CITY OF ALBUQUERQUE

June 12, 2024

Re: Burger King
101 Lomas Blvd. NE
30-Day Temporary Certificate of Occupancy
Transportation Development Final Inspection
Architect's Stamp dated 02-21-24 (J14-D057)
Certification dated 06-10-24

A1.1  
TCL

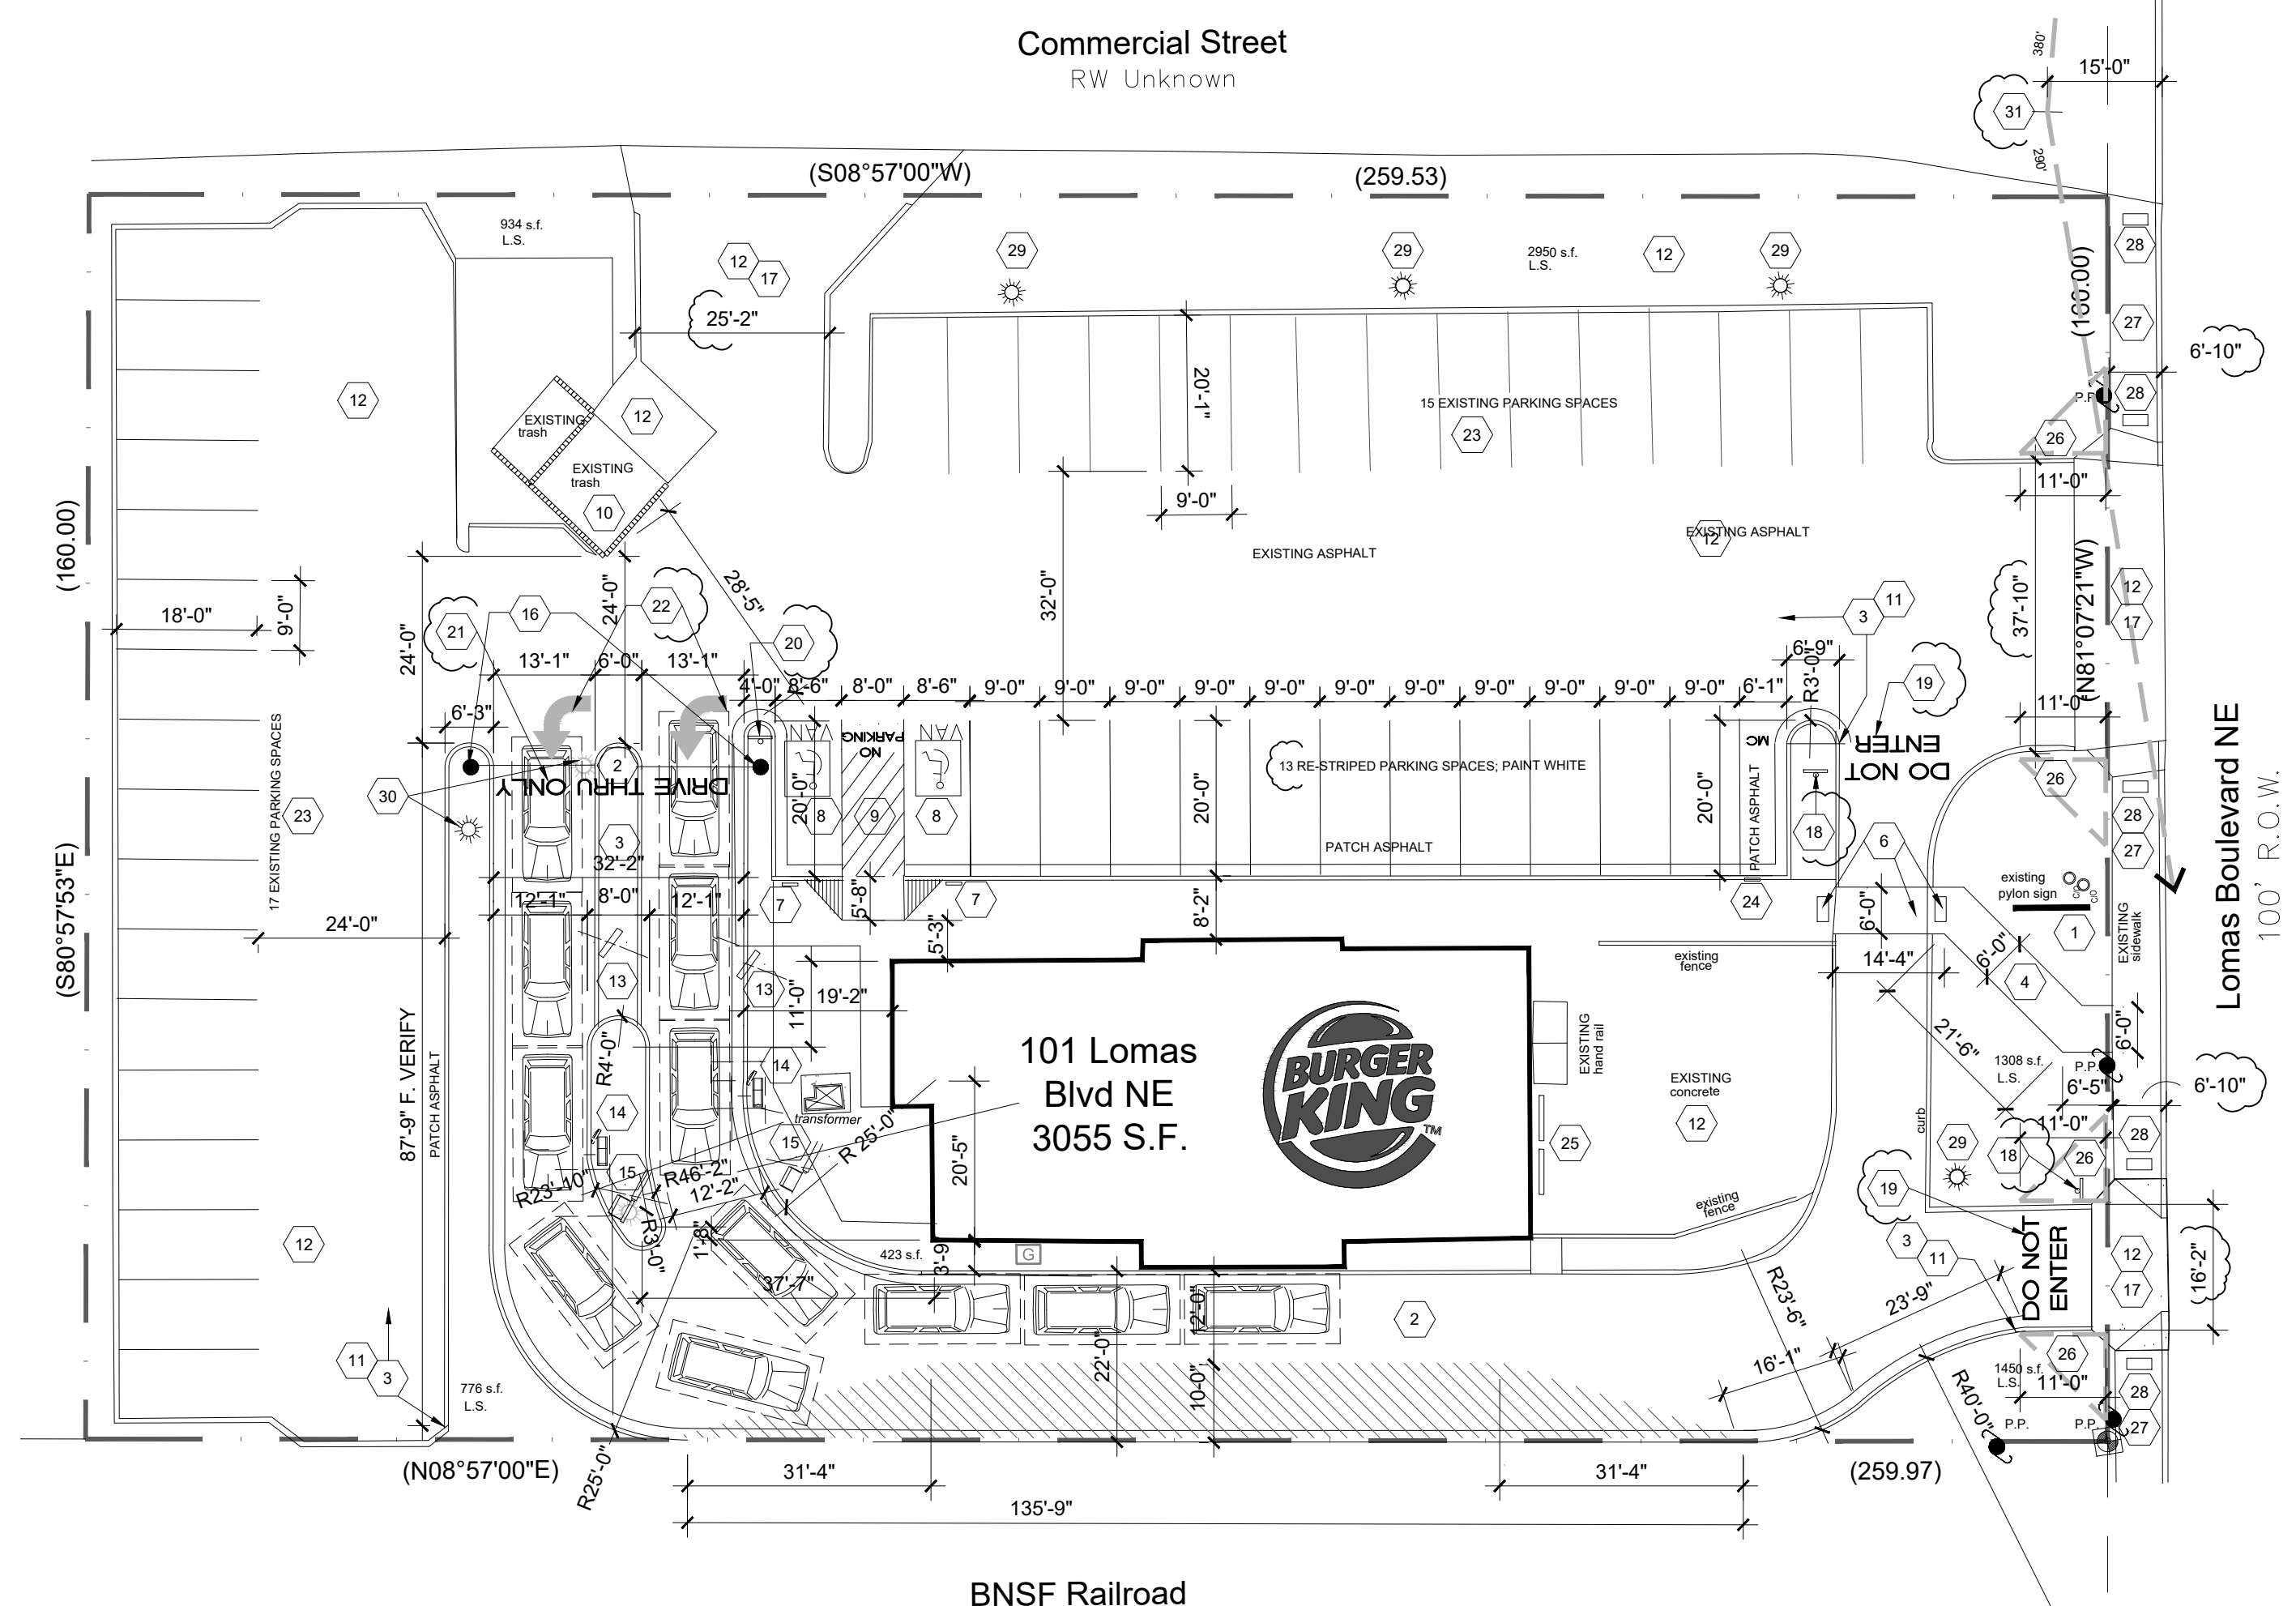
- Anchor down bike rack.
